Town & Country Planning Act 1990 (as amended)
Town and Country Planning (Development Management Procedure) (England) Order 2015
Application for the discharge of conditions imposed on planning reference FG/115/17/PL relating to
5 (transport statement), 6 & 8 (Landscaping) & 10 & 11 (Materials) & 12 (fencing, bins)
44 Ferringham Lane Ferring,,

Arun District Council have decided to **REFUSE** details reserved by condition for the following reasons:

SCALE 1:200 @ A1
DATE 14.05.2017
DRAWN sed
DWG No. 628-02 rev. G

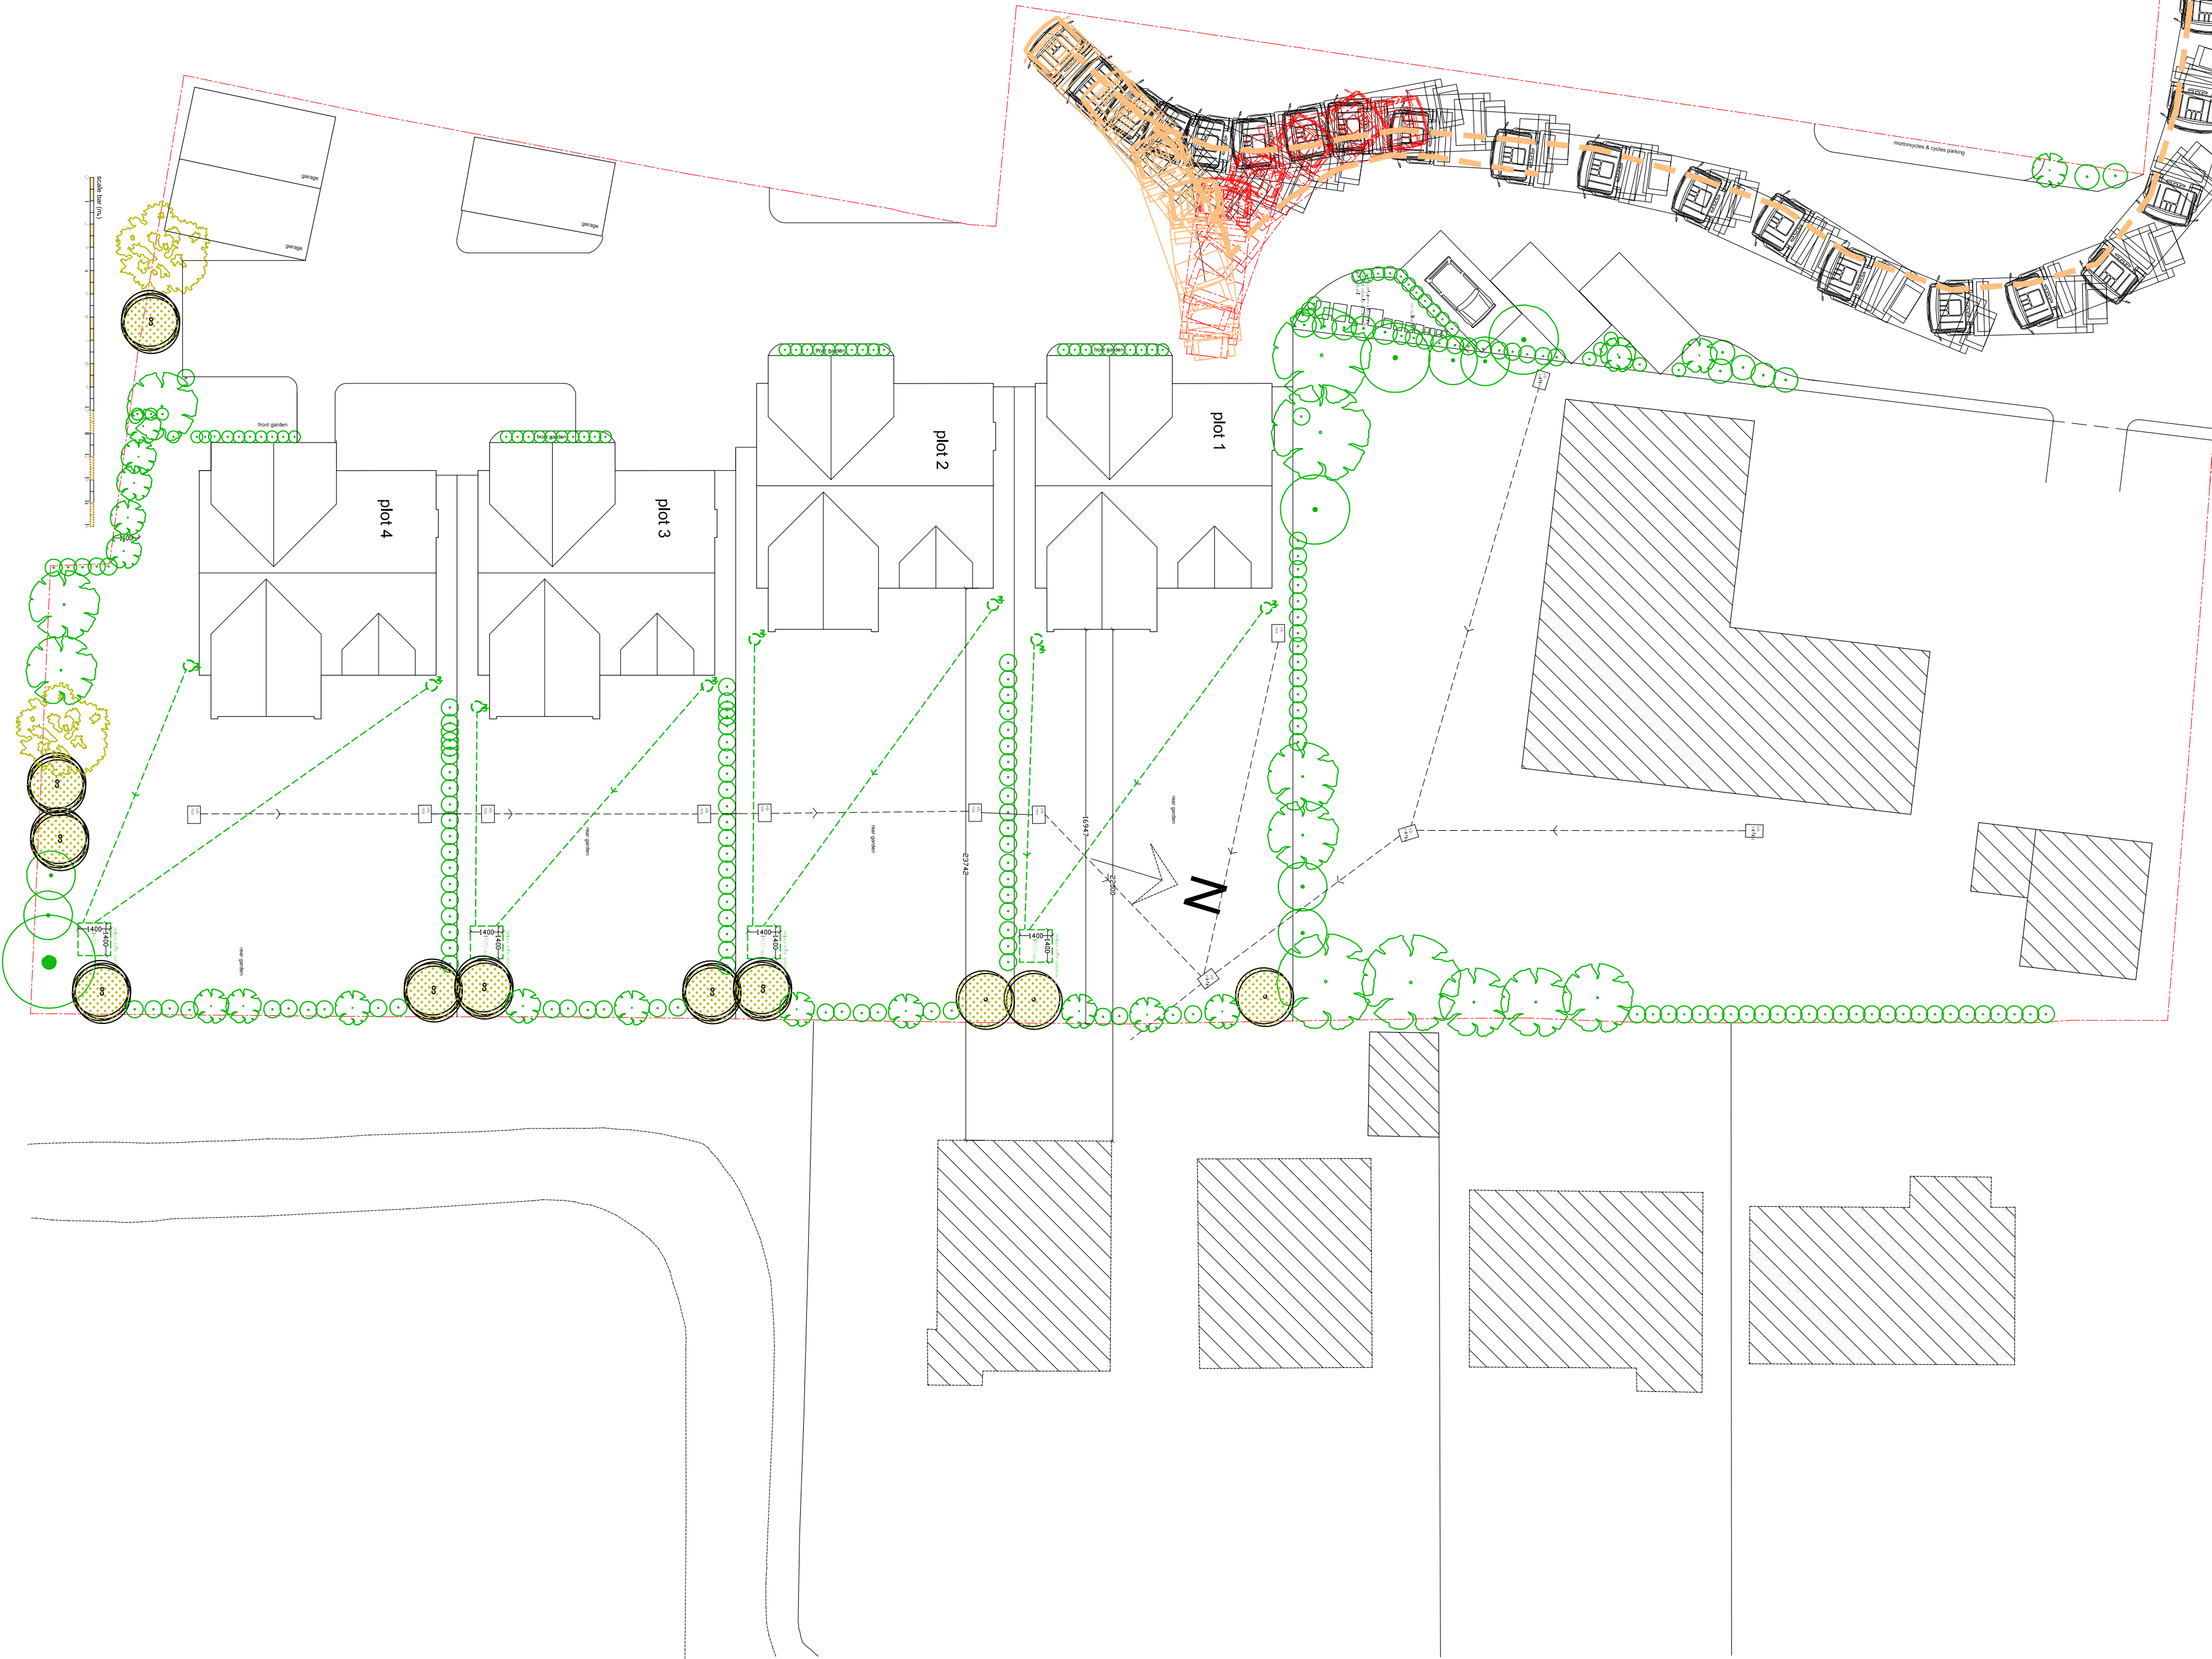
This condition cannot be discharged given the lack of any details relating to fencing along the site boundaries. There is no reference to retention or provision of new boundary treatments in these areas. A plan should be submitted clearly identifying all fencing within and around the site boundaries as well as those within the site
